August 3, 2006

RE: Vantage Bay Rezone (Z-06-25) and Preliminary Plat (P-06-26)

Grant PUD's review of the Vantage Bay rezone and preliminary plat has raised a number of broad issues as well as several specific review comments. From the broader point of view, Grant PUD has concerns about the following:

EQUIPMENT USED:
TOPCON GTS 303D 5
SECOND TOTAL
STATION OR TOPCON
HIPER SERIES GPS
WITH A MINIMUM
LINEAR CLOSURE OF
1:10,000 IN
CONFORMANCE WITH
REQUIREMENTS OF
WAC 332-130-090.

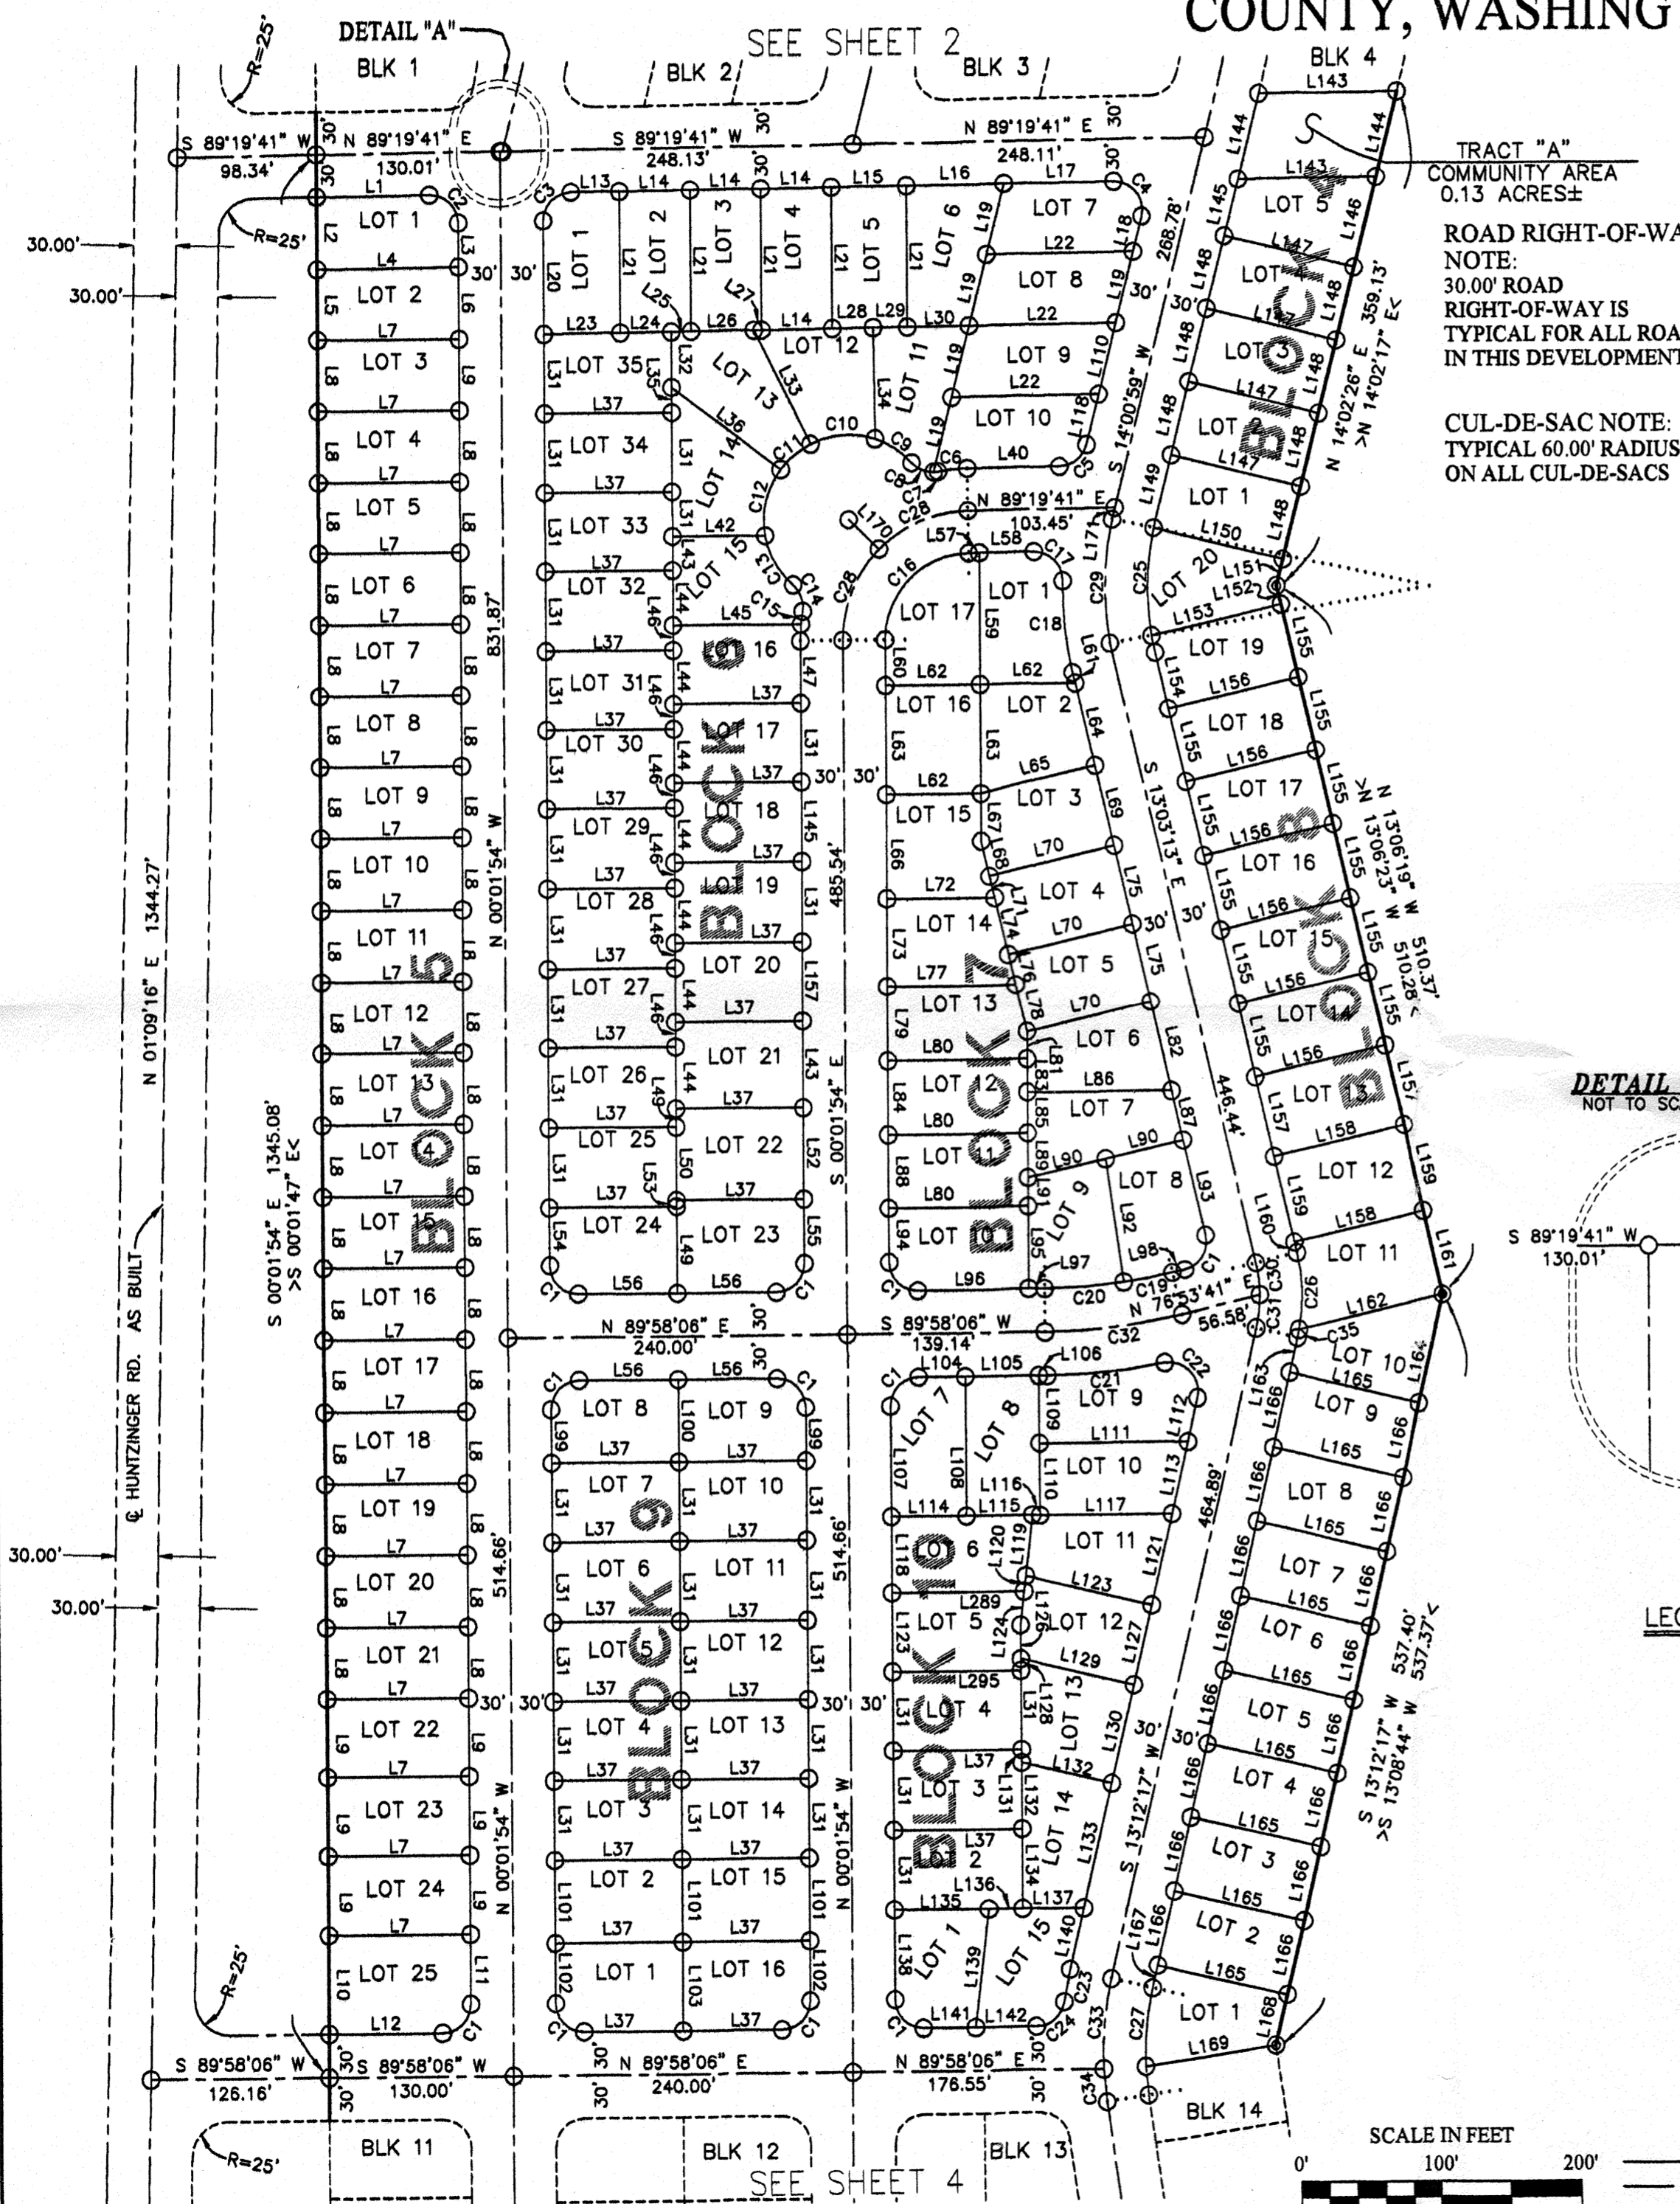
- The proposed location of the Tract A and Tract B Community Areas will provide access to the Grant PUD-owned shoreline. Shoreline uses are regulated by FERC and permits issued by Grant PUD will be required for any community access other than non-motorized undeveloped ingress/egress.

- Grant PUD requests dedicated public ingress and egress for motorized vehicle access over the road proposed to extend from Huntzinger Road to Tract A Community Area, and over the proposed Tract A Community Area.

- Grant PUD requests dedicated public ingress and egress for non-motorized trail access adjacent to the road proposed to extend from Huntzinger Road to Tract A Community Area lot, and over the proposed Tract A Community Area lot.

- Grant PUD requests a 10-foot wide unobstructed easement running parallel to the Grant PUD property line. This easement should be located within the plat on property owned by the developer and dedicated to community ingress and egress for non-motorized access to Tract A and Tract B Community Areas proposed in the plat. This easement will provide a community thoroughfare to the Grant PUD-owned shoreline properties for use as a non-motorized trail system.

- Grant PUD recommends installation of fencing delineating private and public property on the easterly property boundary to prevent future encroachment, and minimize ground disturbances and vegetation damage.

- The plat as proposed does not adequately address the storage and guest space needs of the lots. The lots as proposed are scarcely large enough to build a single-family house, to say nothing of the guest parking, boat storage, and other space needs that will surely accompany second-home, resort residential development.

- The proposed lot sizes in the plat are not in keeping with the open, natural appearance of the Vantage area, especially the adjoining public lands (Grant PUD and Washington State Parks).
